Lime Down Solar Project — Open Floor Hearing 1

21 April 2026 • Danny Pike, Secretary, CAWS (speaking also for Melksham Without Parish Council)

Figure 11-8.2: Lime Down Cable Route  
Fluvial Flood Risk

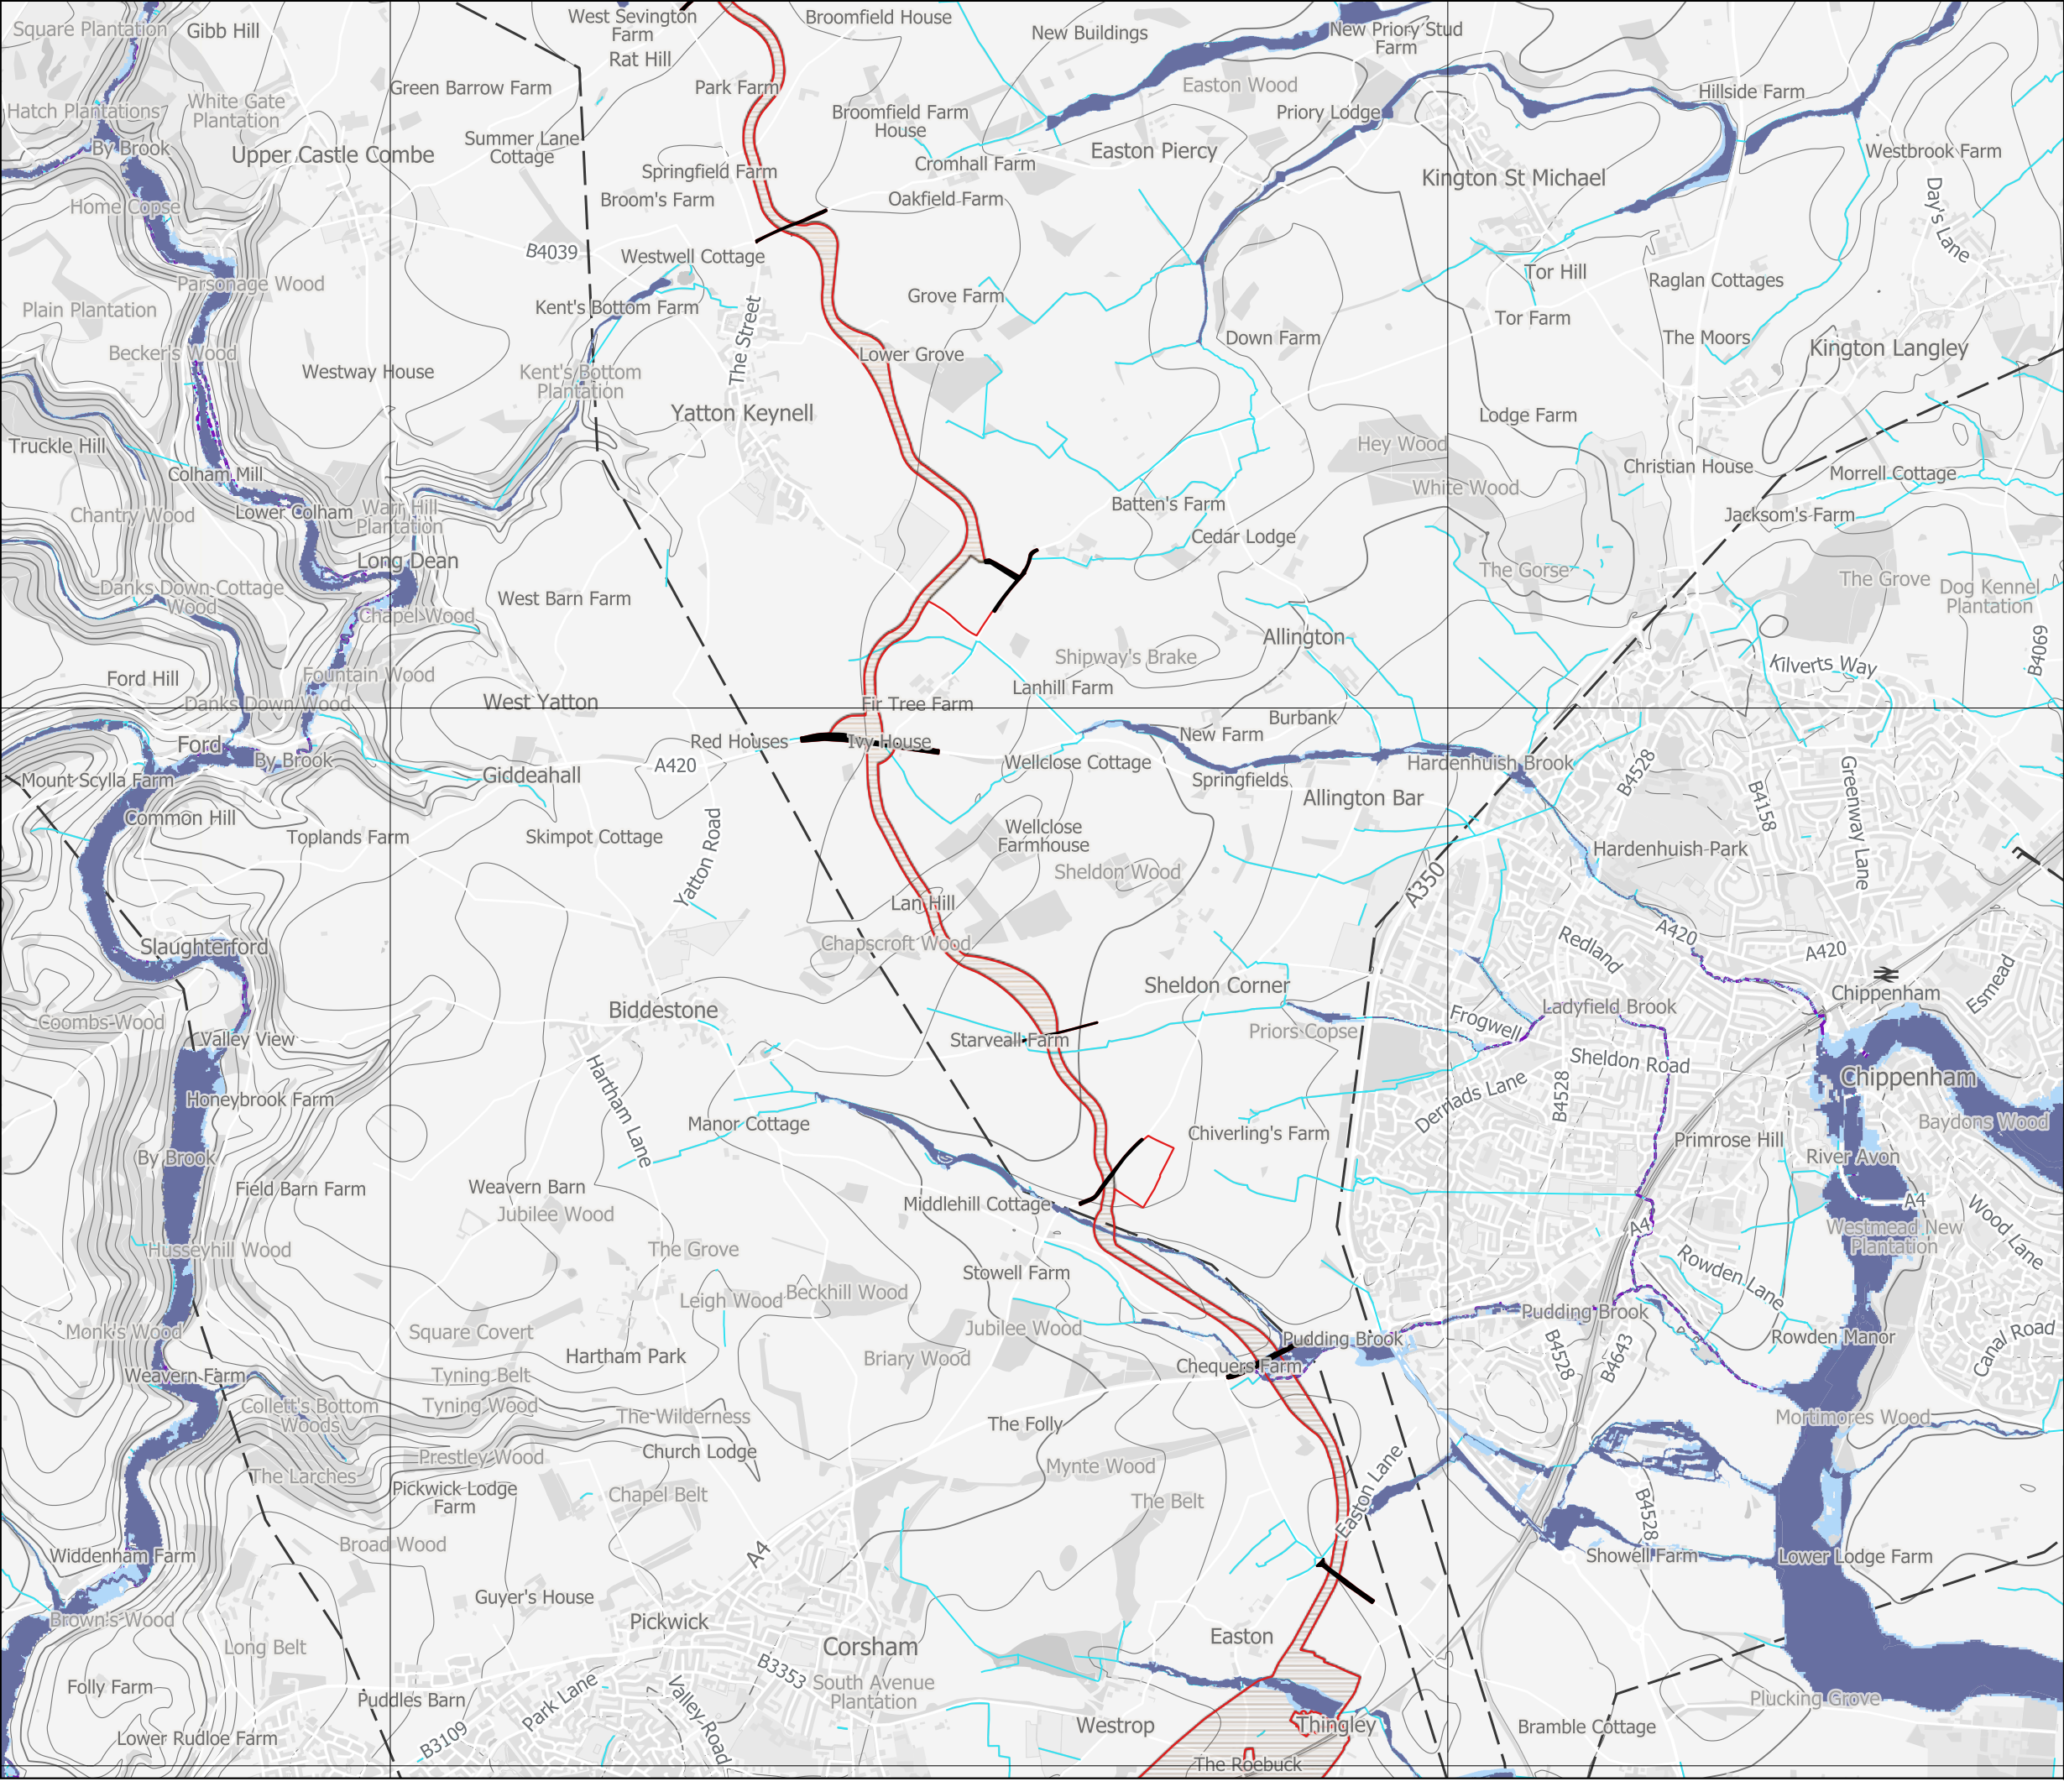
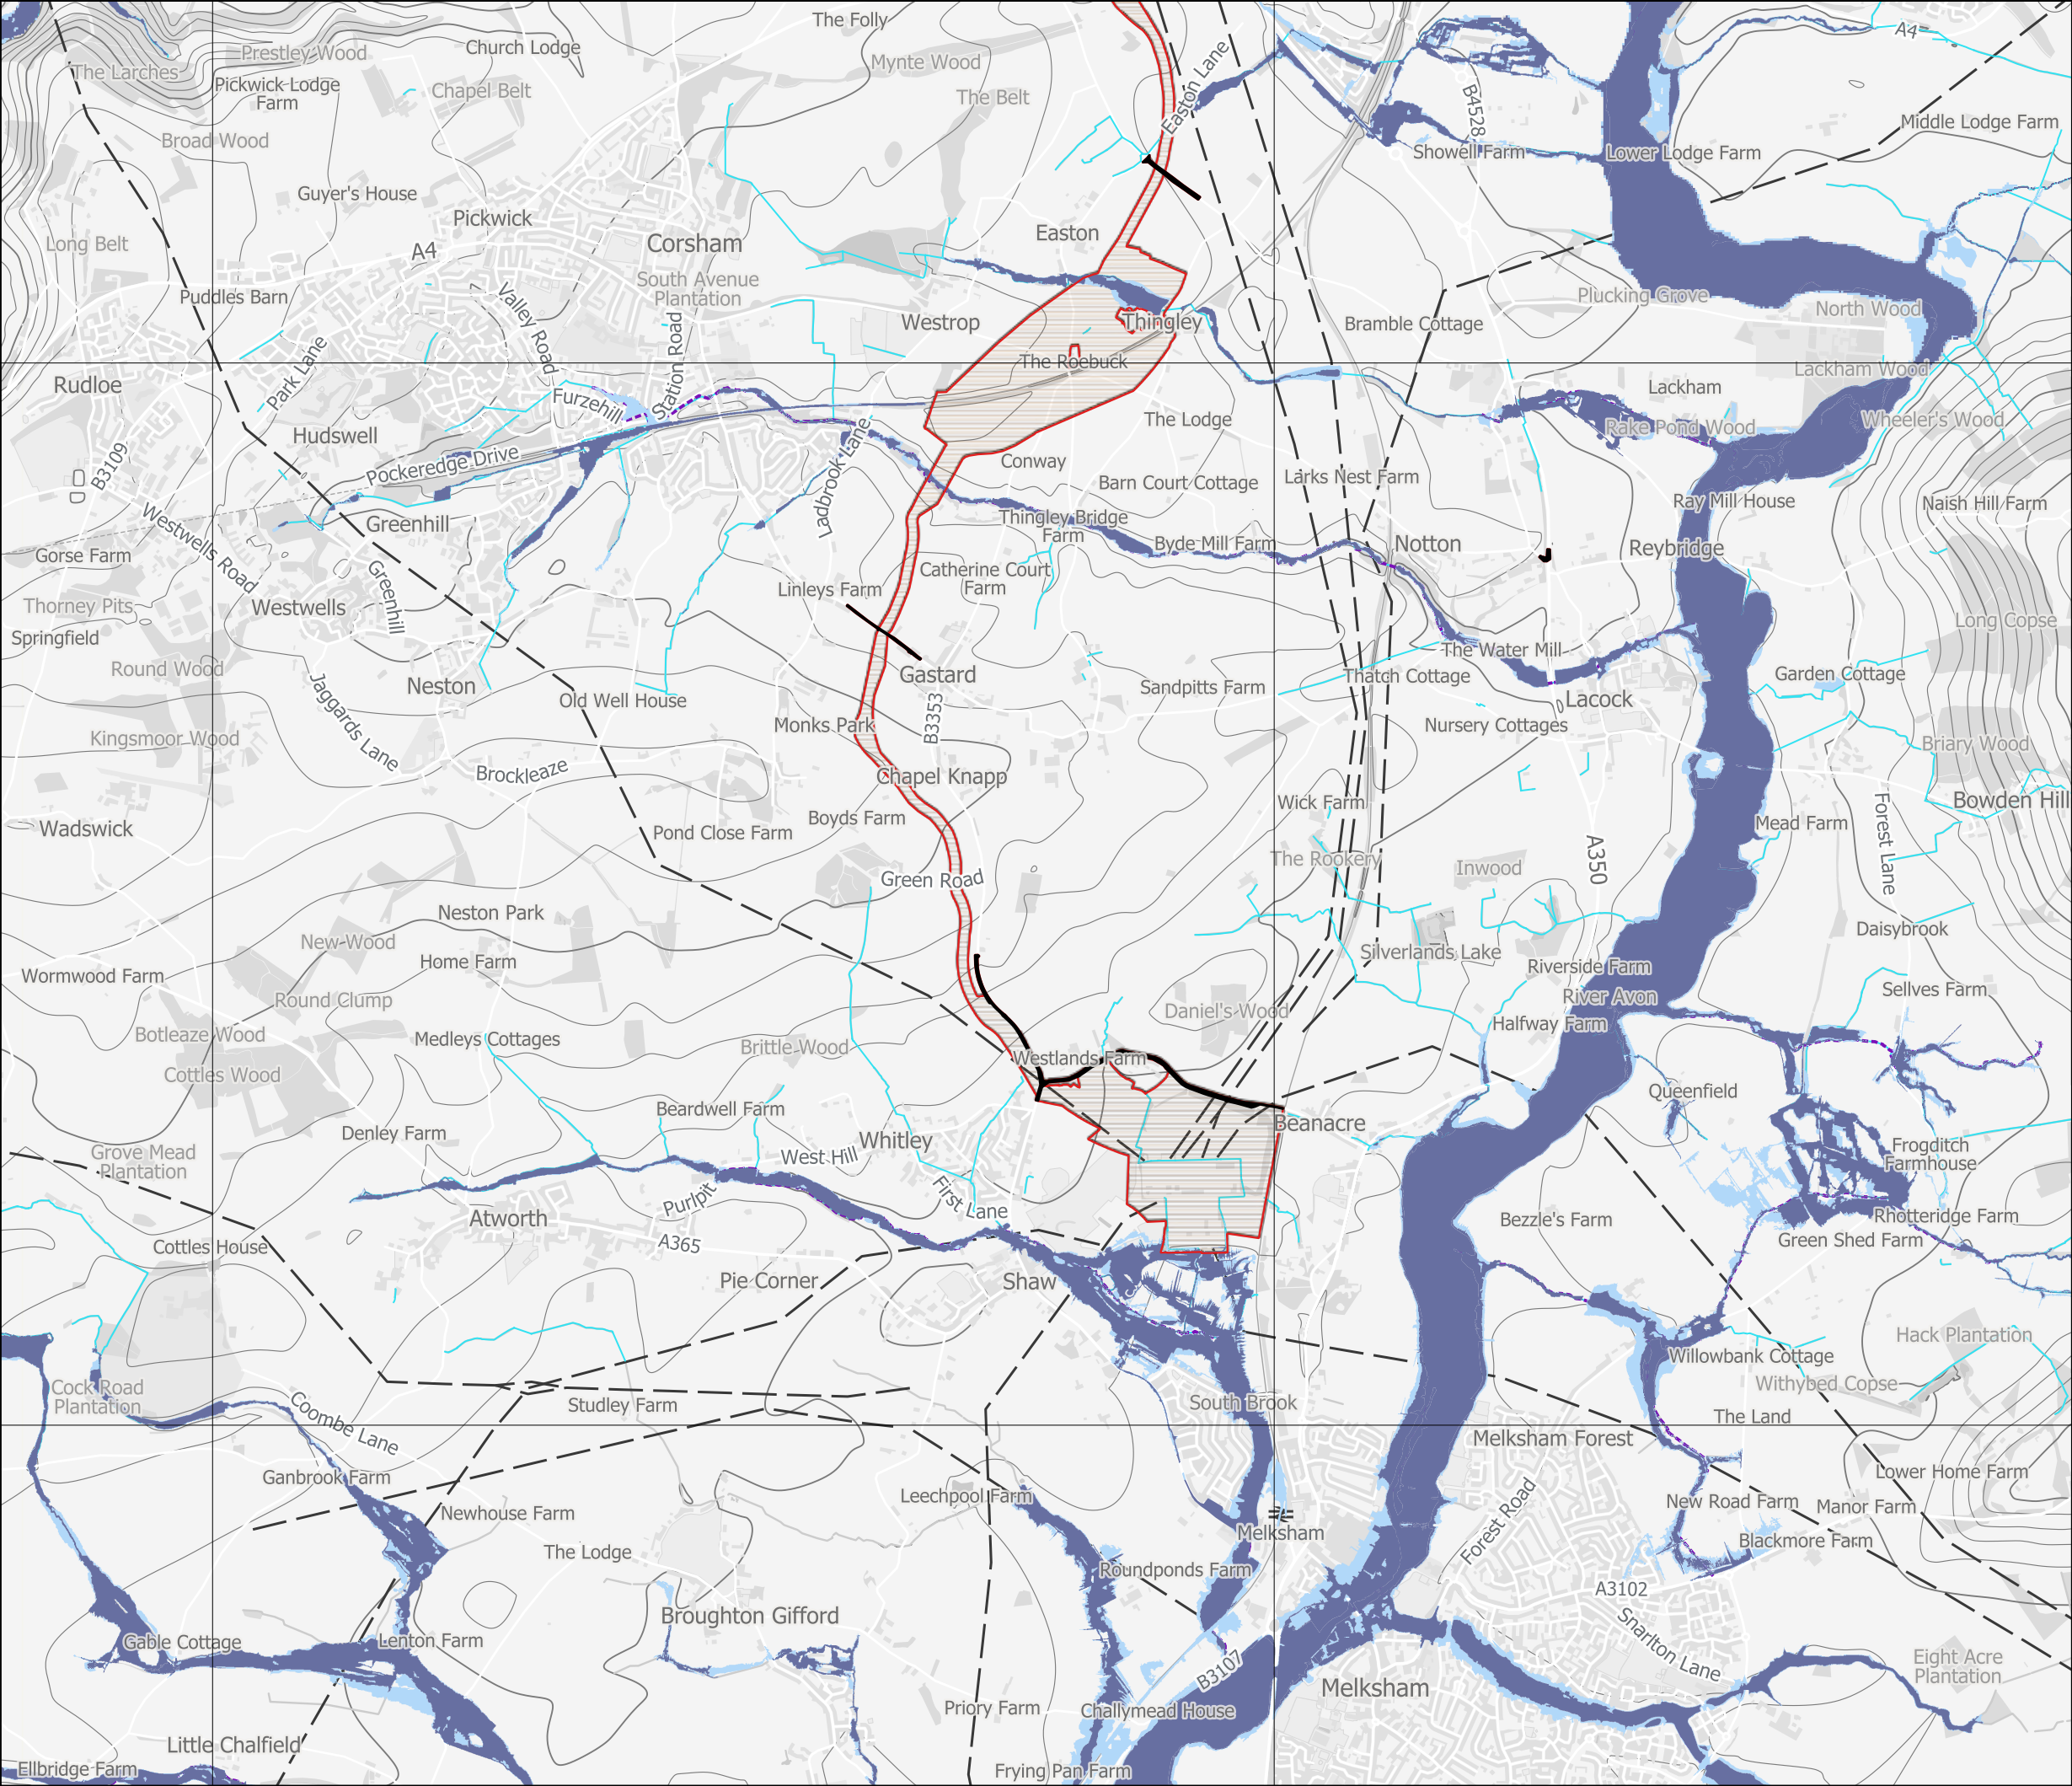
Whitley and Shaw are two small villages that sit at the foot of a dense headwater catchment. When several headwaters are disturbed during construction, the flow downstream includes both sediment and contaminants moving through connected drainage, and into the wider river basin. The effects are cumulative, yet that catchment has not been assessed as a catchment by the Applicant.
